CITY OF ALBUQUERQUE

June 21, 2013

Re: America's Pasttime
Lot 30A3, North Albuquerque Acres
Request for Permanent C.O. – Rejected
Temporary C.O. – Accepted (30 Day)
Engineer's Stamp dated: 12-04-2012 (C-18/D035)
Certification dated: 06-19-2013

AMERICA'S PASTTIME
GRADING & DRAINAGE PLAN

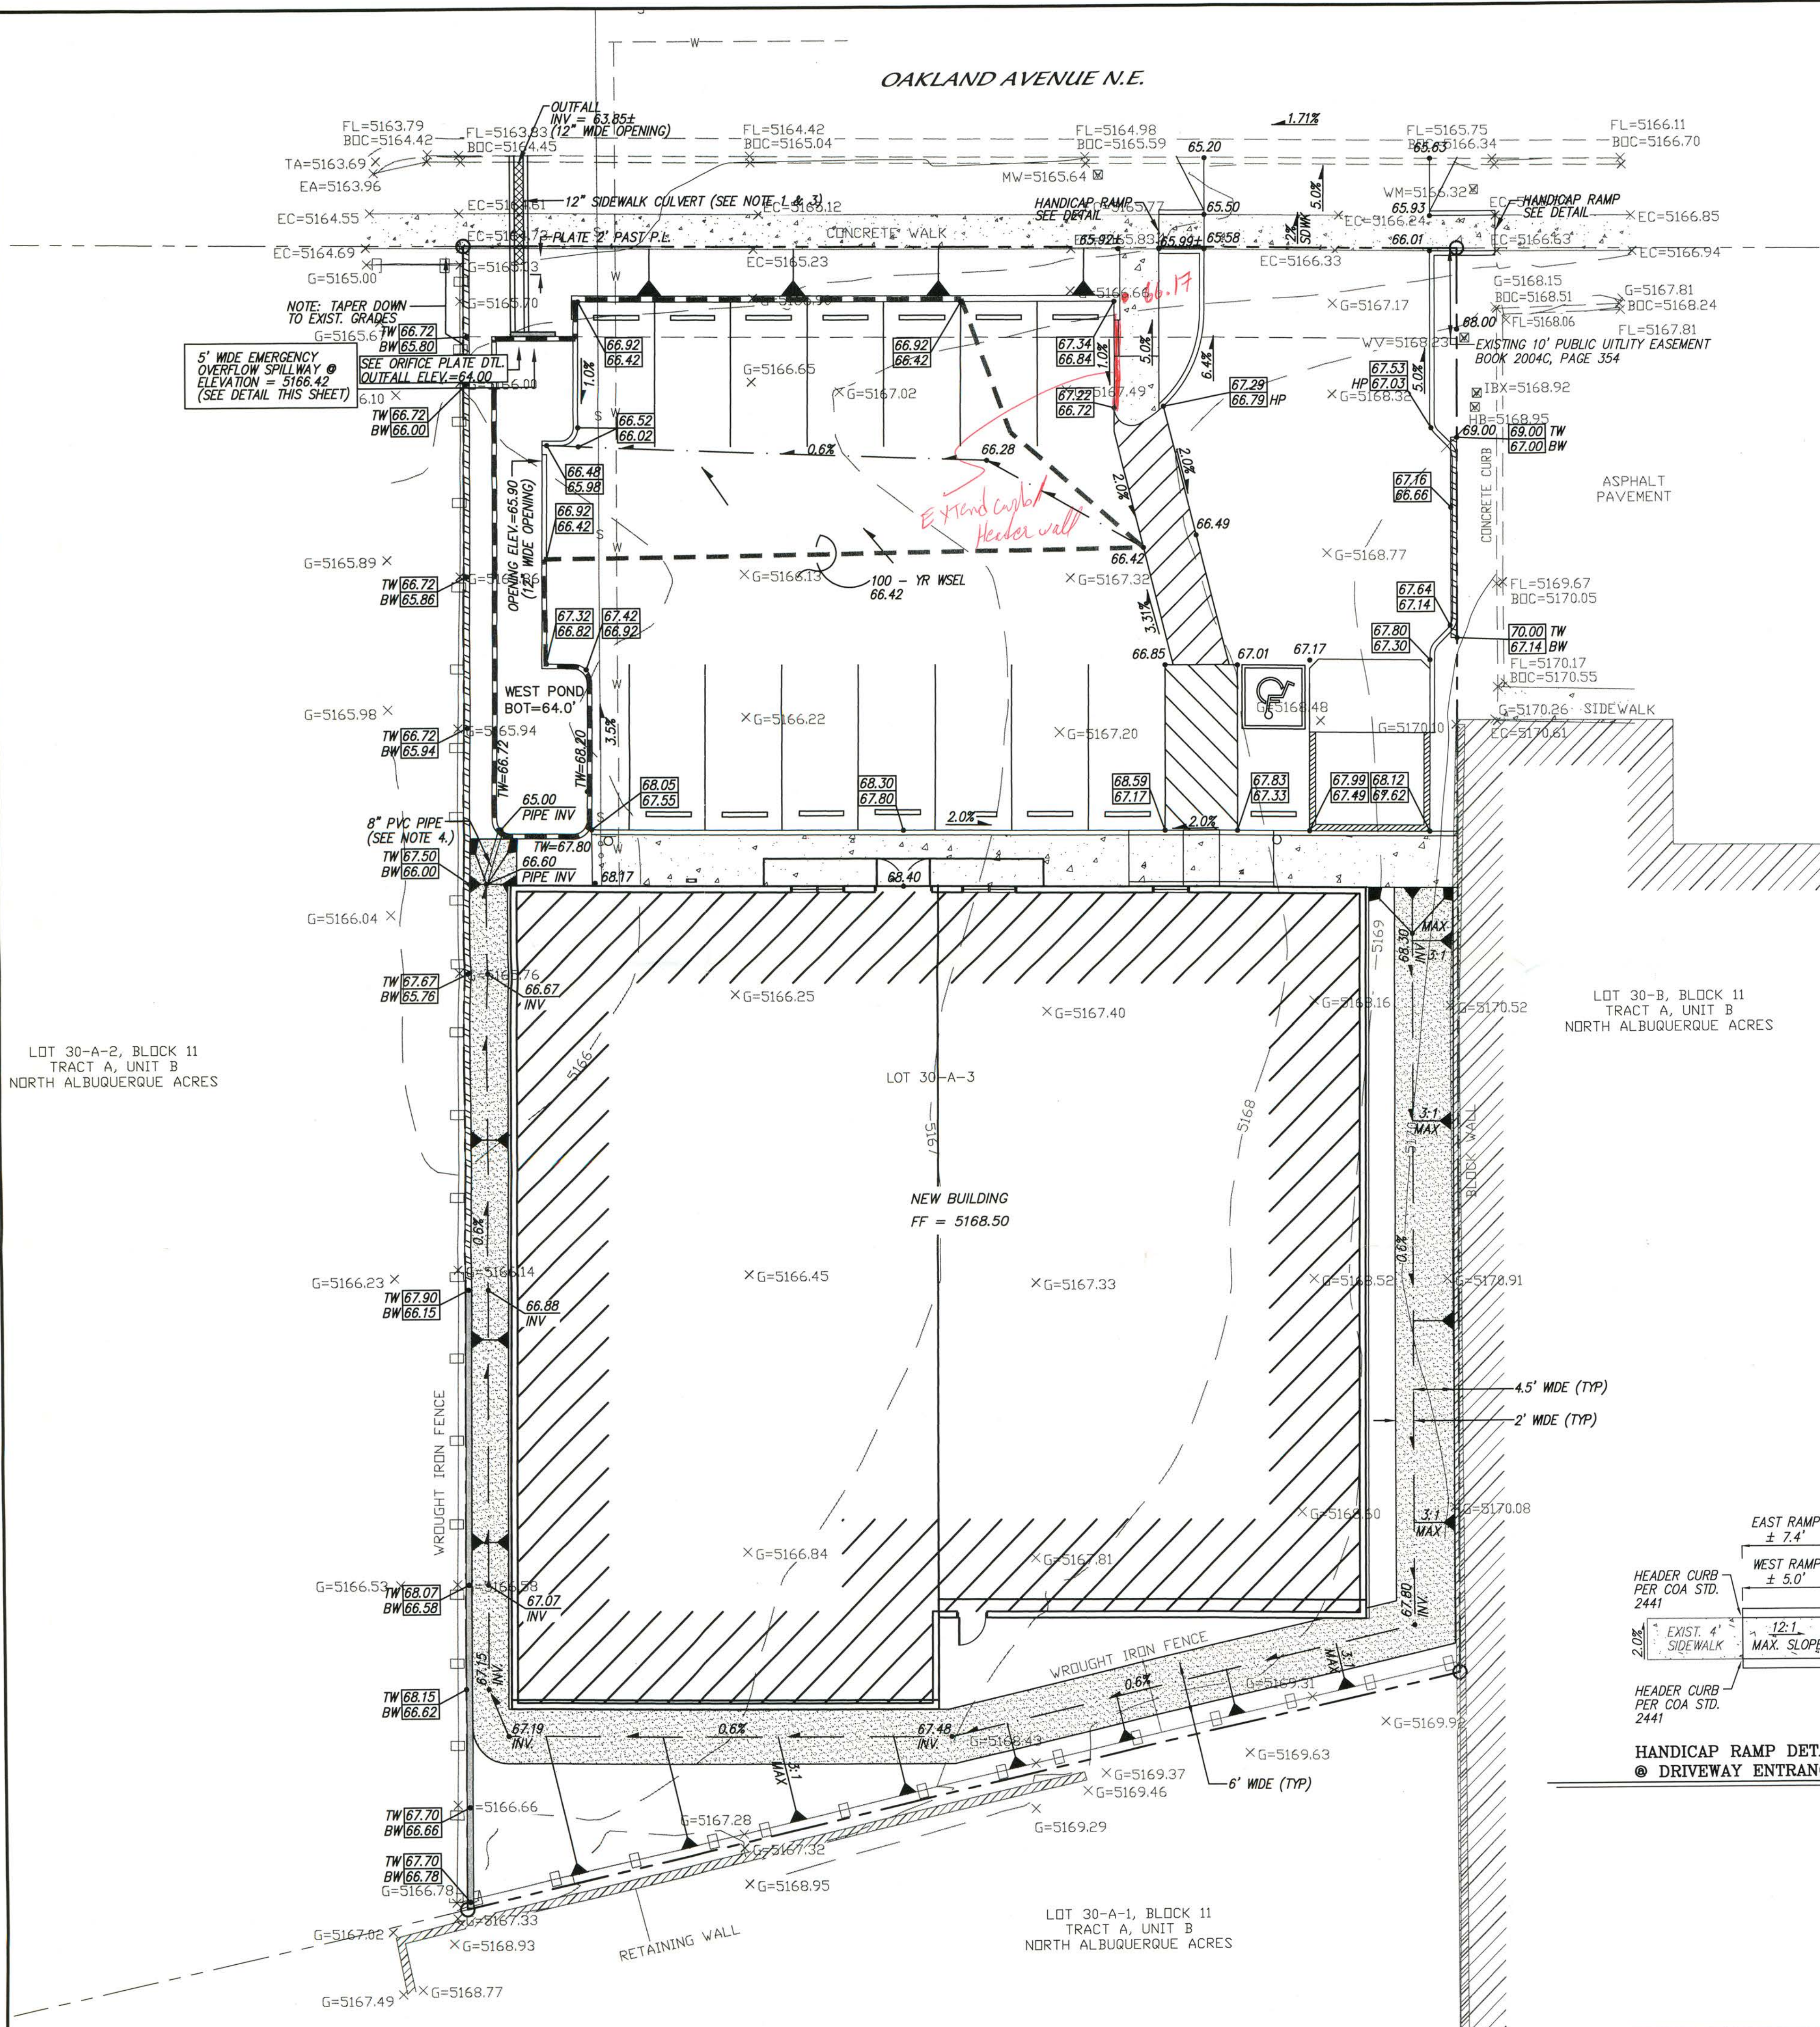
- The emergency spillway on the detention pond is not 5 feet in width as approved on the grading and drainage plan. Provide detailed analysis on the operation of the detention pond with a smaller spillway opening. Clarify the size of the spillway opening.
- Provide as-built spot elevations at the pond inlet from the parking lot, at the invert of the orifice plate, at the opening of the emergency spillway, at the top-of-wall of the spillway and at the end of the speed hump along the entrance.
- Extend the speed hump in the parking lot to the face of curb to prevent these flows from exiting through the driveway.
- Construct the sidewalk culvert to the specifications that were discussed in field with the contractor on June 20, 2013.
